**Application no: 23/01033/DISC**

**Location: Axis J9 Phase 3, Howes Lane, Bicester**

## **Transport Development Control**

Project  
**Axis J9  
 Bicester  
 Phase 3**  
 Drawing Title  
**Proposed Utilities Layout**

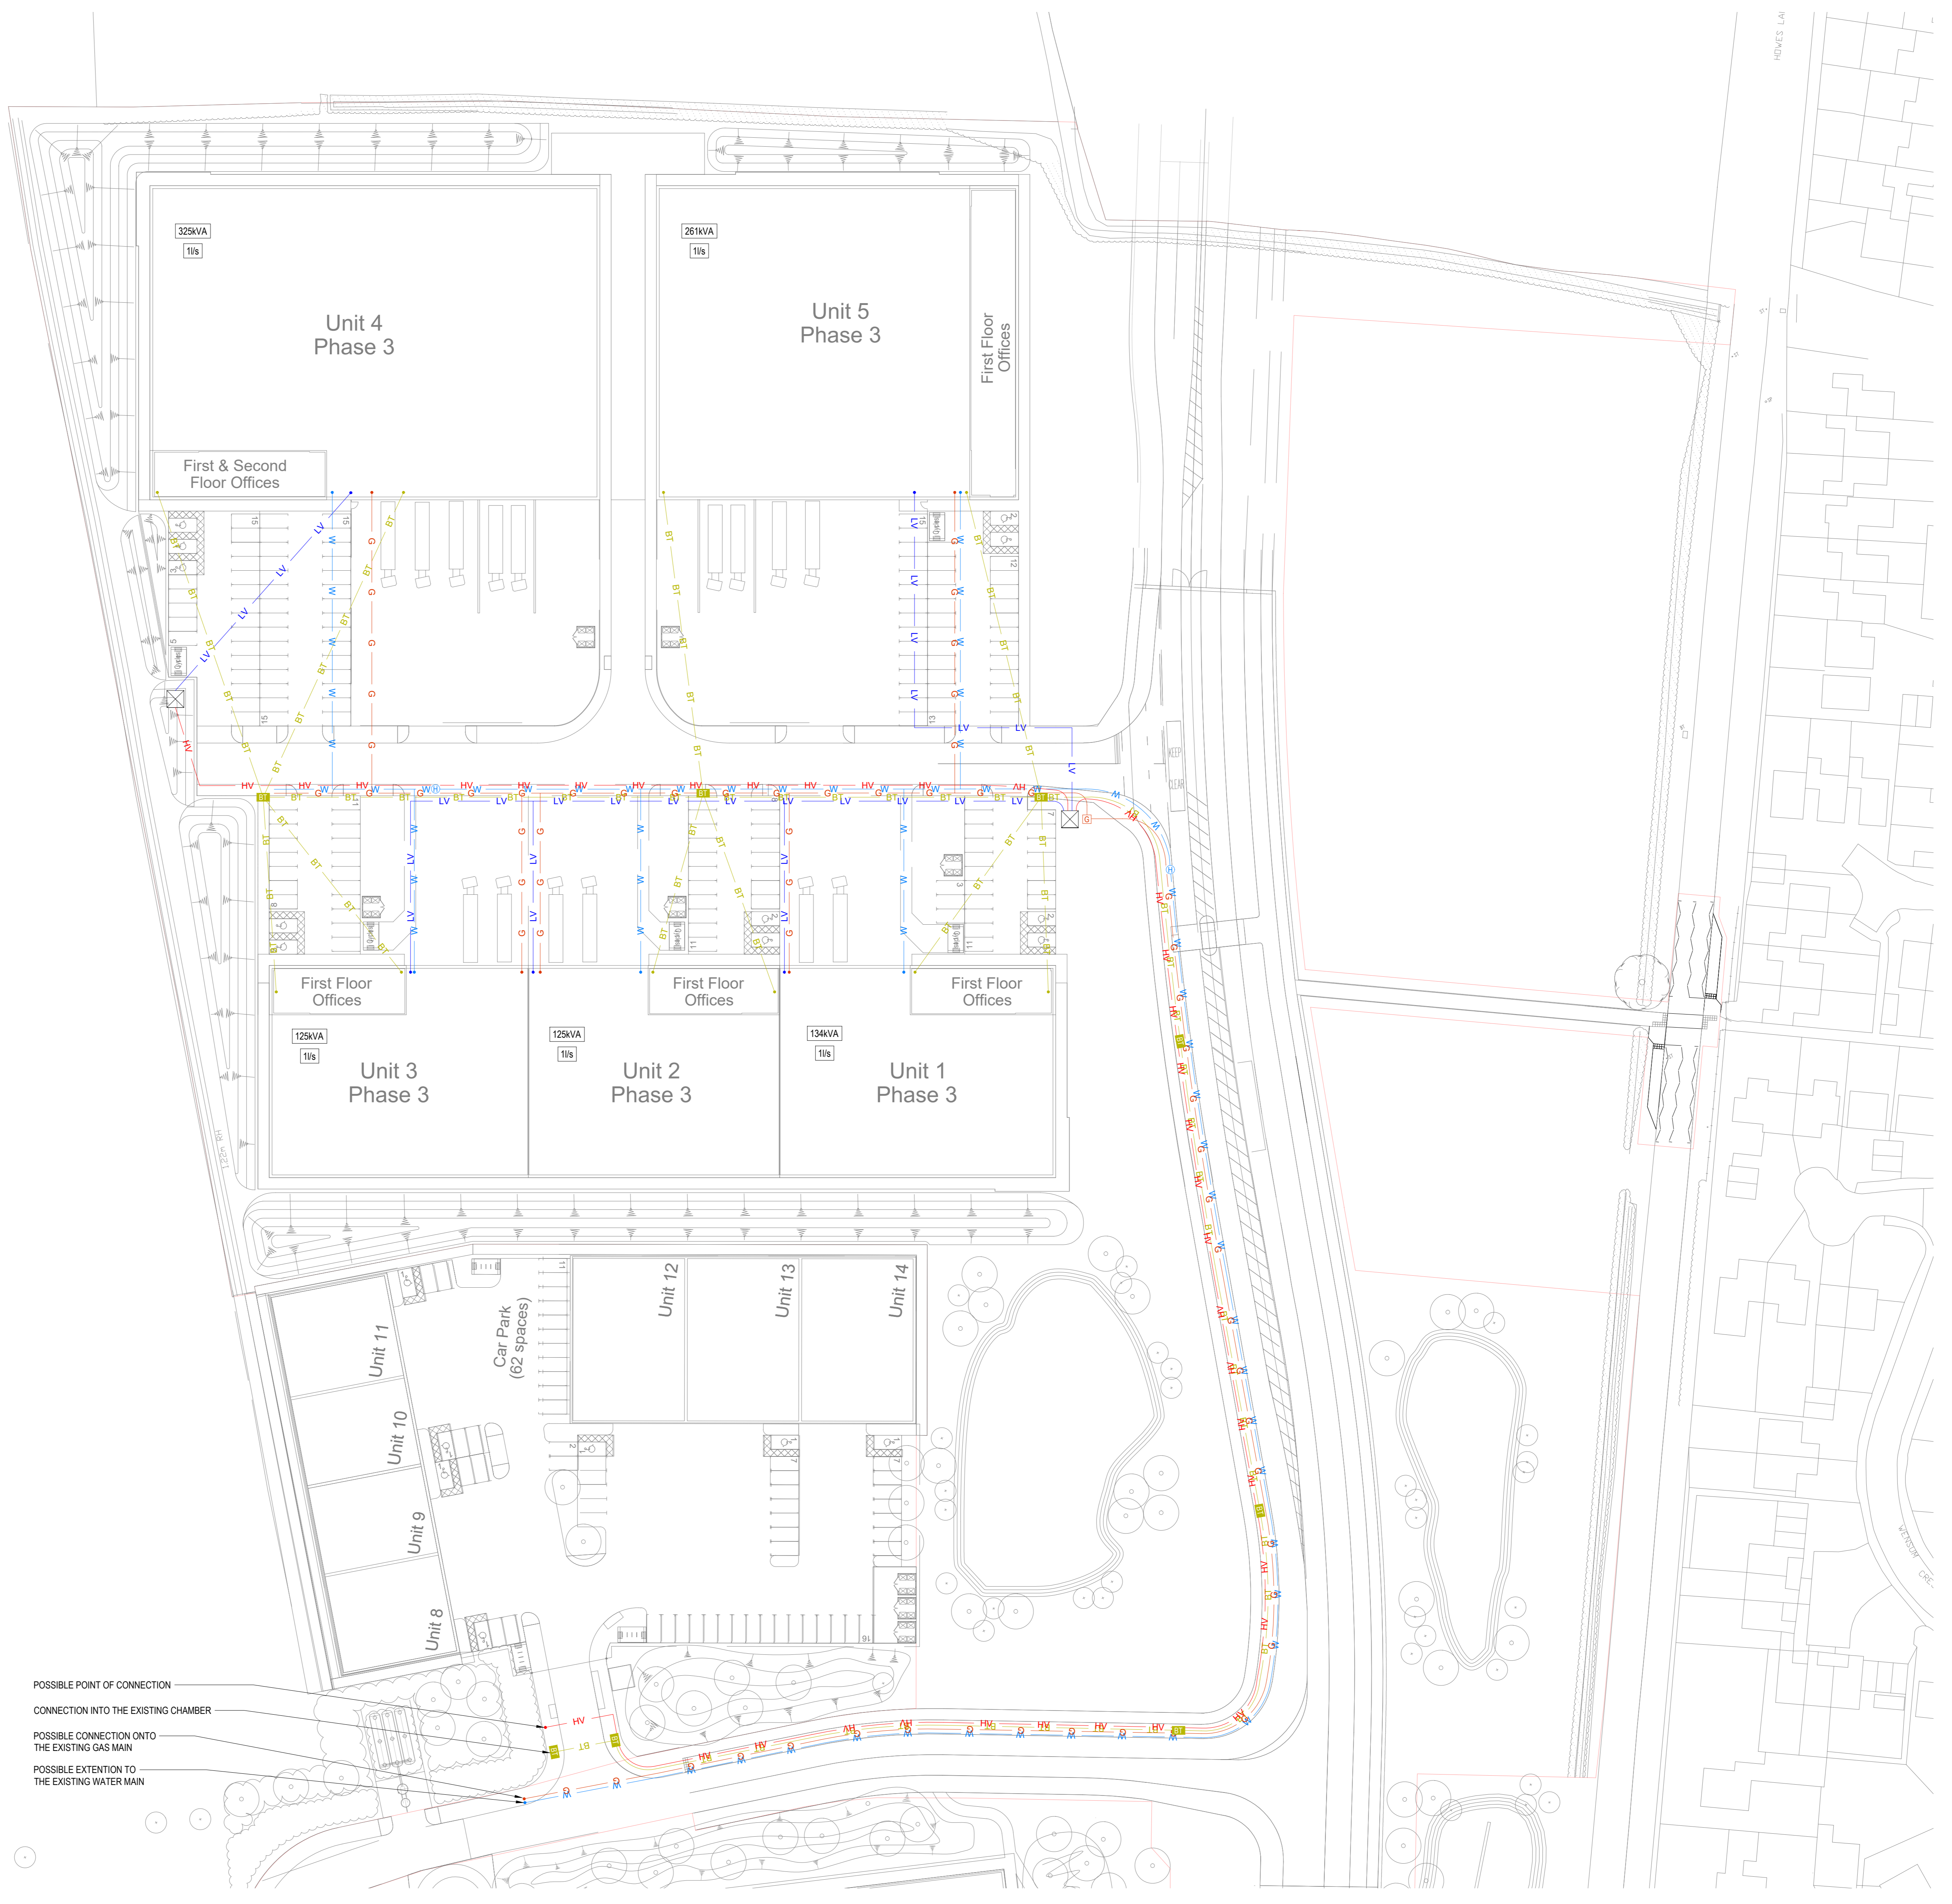
However, please note that covers should be avoided within the cycle lane or be of a non-slip type.
